Your ref:	87 Chester Row Third Scheme	Please reply to:	Fraser Fikrie
Our ref:	23/08701/FULL	Tel No:	0753424 7967
		Fee Queries:	0207 641 6500;
		Email:	planningreception@westminster.gov.uk;
Mr Sam Dargue Savills 33 Margaret Street London W1G 0JD United Kingdom		Incomplete Applications Town Planning & Building Control City of Westminster PO Box 732 Redhill, RH1 9FL	
		3 January 2024

Address: 87 Chester Row, London, SW1W 8JL,

Proposal: Use of ground floor level as a single residential dwelling (Class C3) in connection with the first and second floor use and associated external alterations at ground floor; infill extension at second floor level; installation of windows to flank elevation at first and second floor levels; formation of roof terrace and associated access; and installation of air source heat pump and solar PV panels to roof.

Thank you for your application received on 15 December 2023. I am writing to inform you that your application is incomplete for the following reason(s):

drawing title
PROPOSED PLAN
FIRST FLOOR

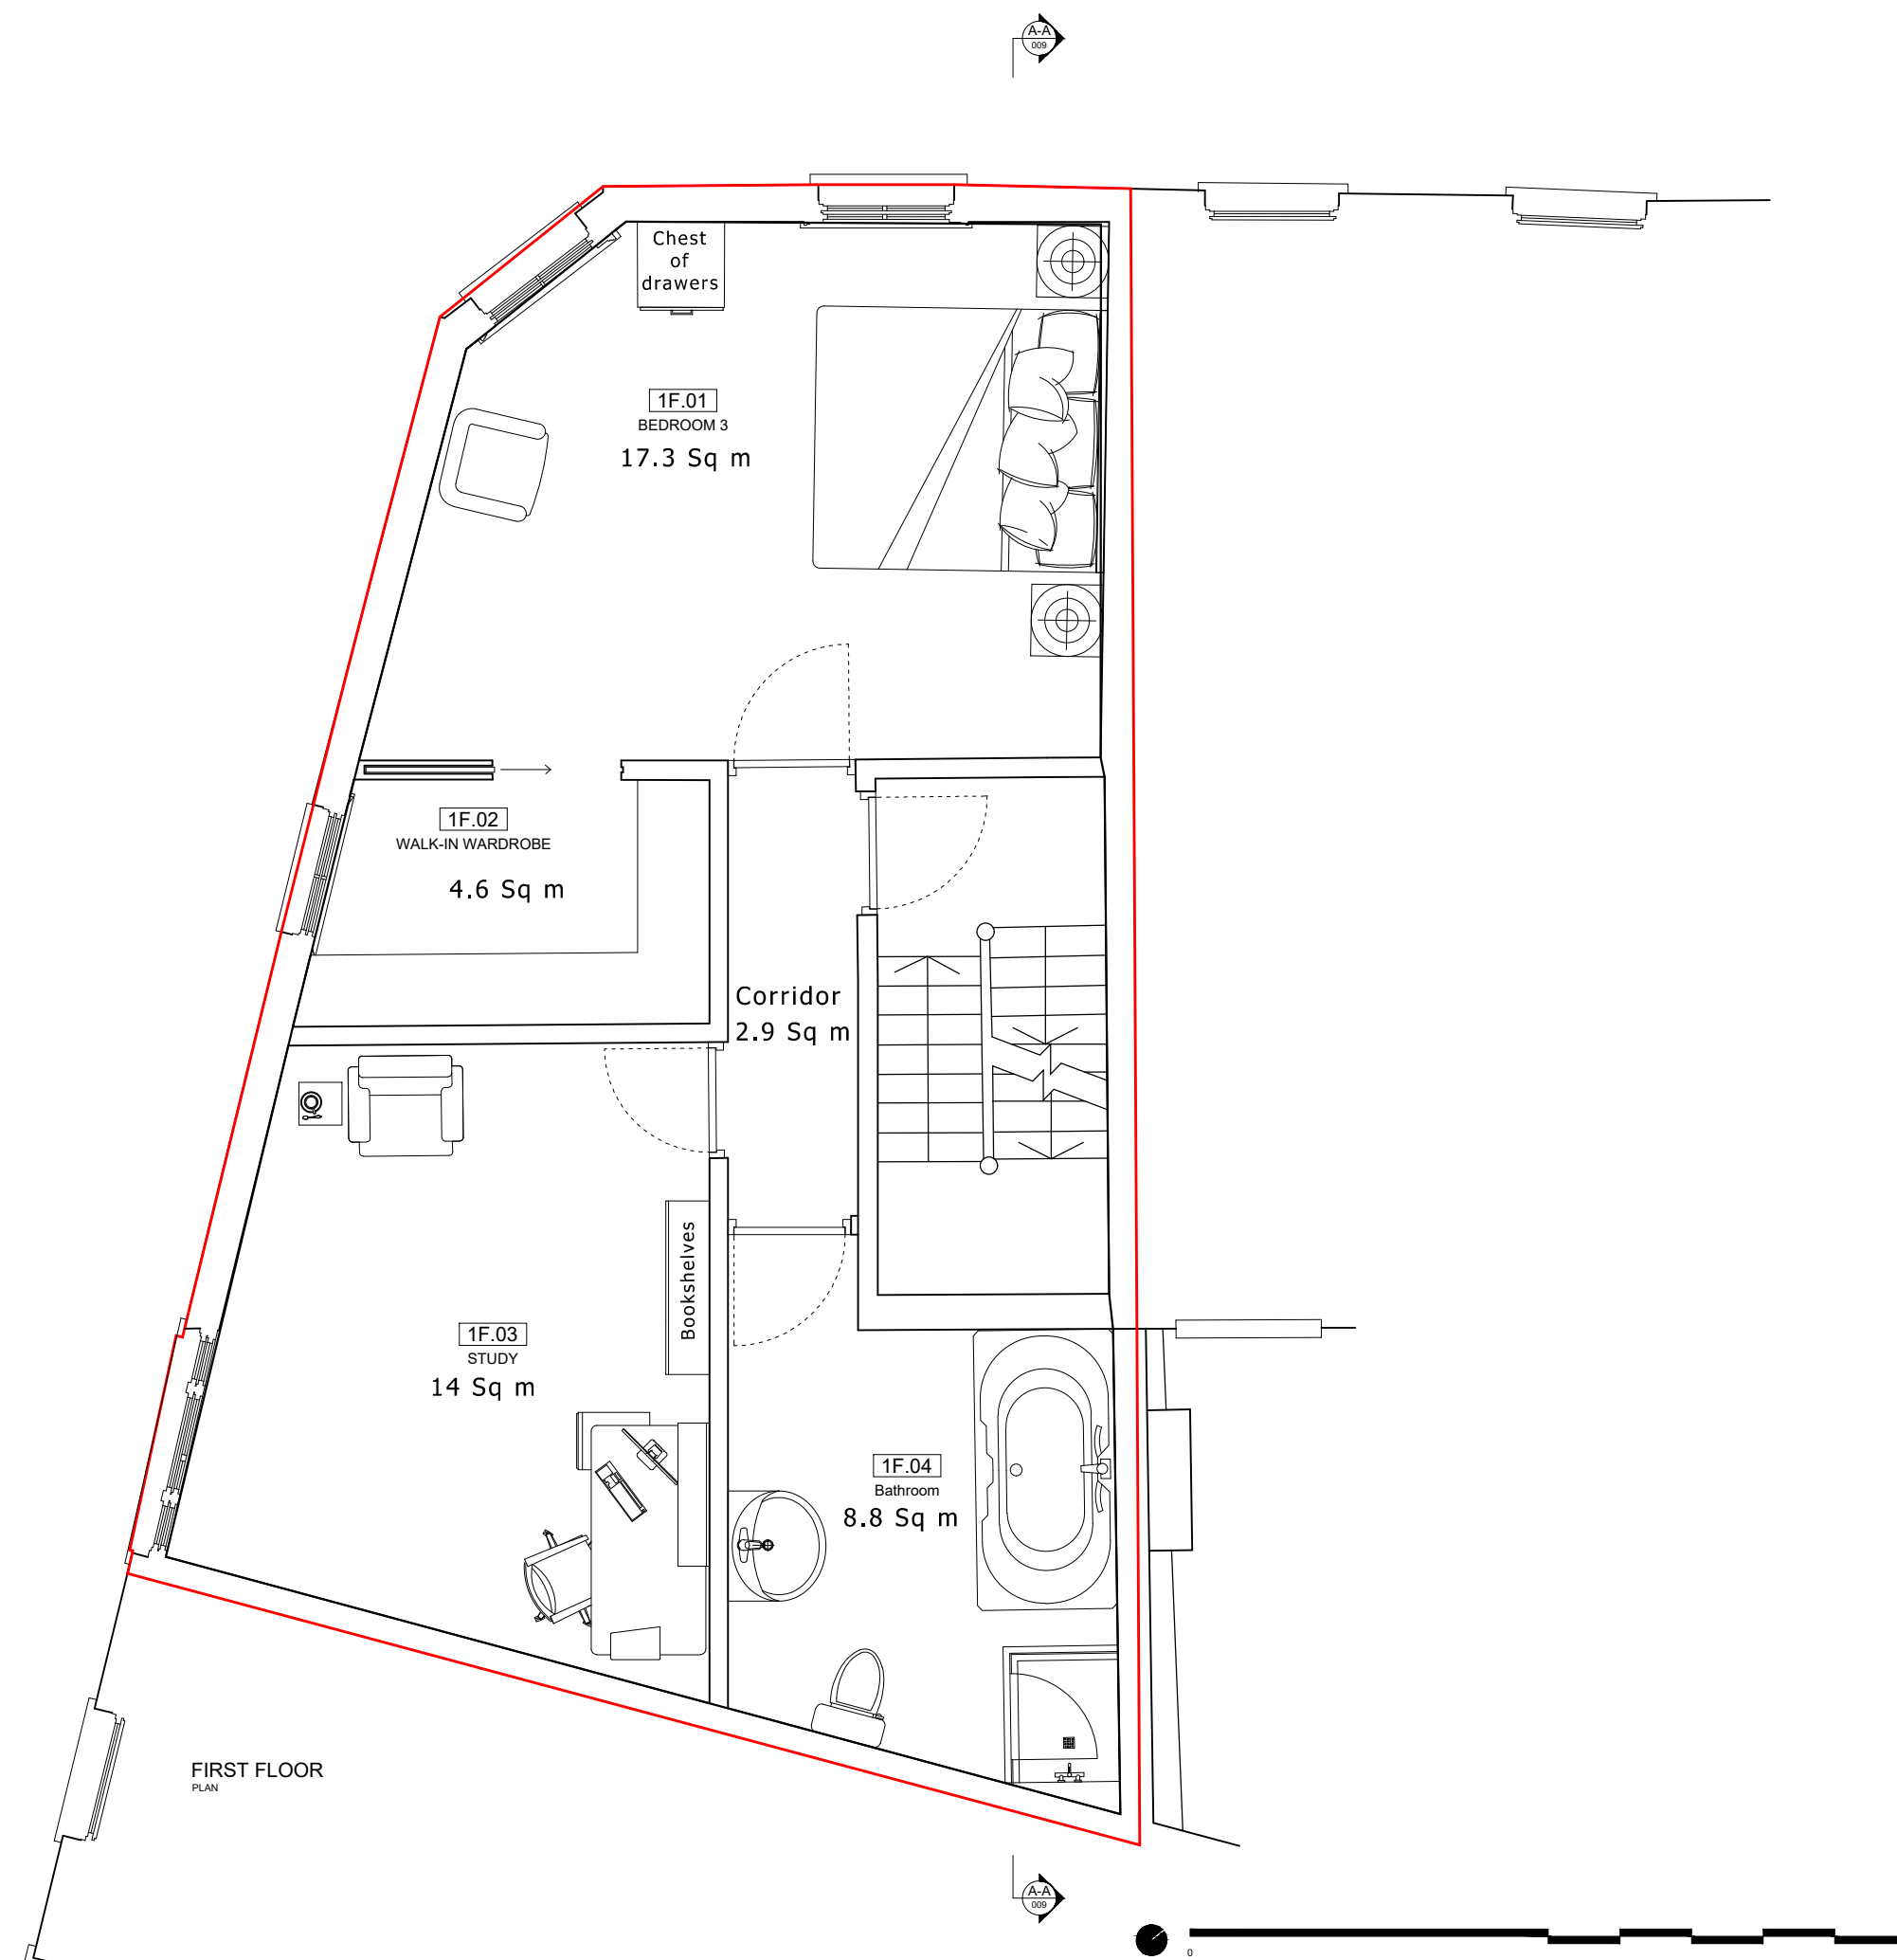
- 2 Please provide detailed drawings (section through) of the proposed windows.
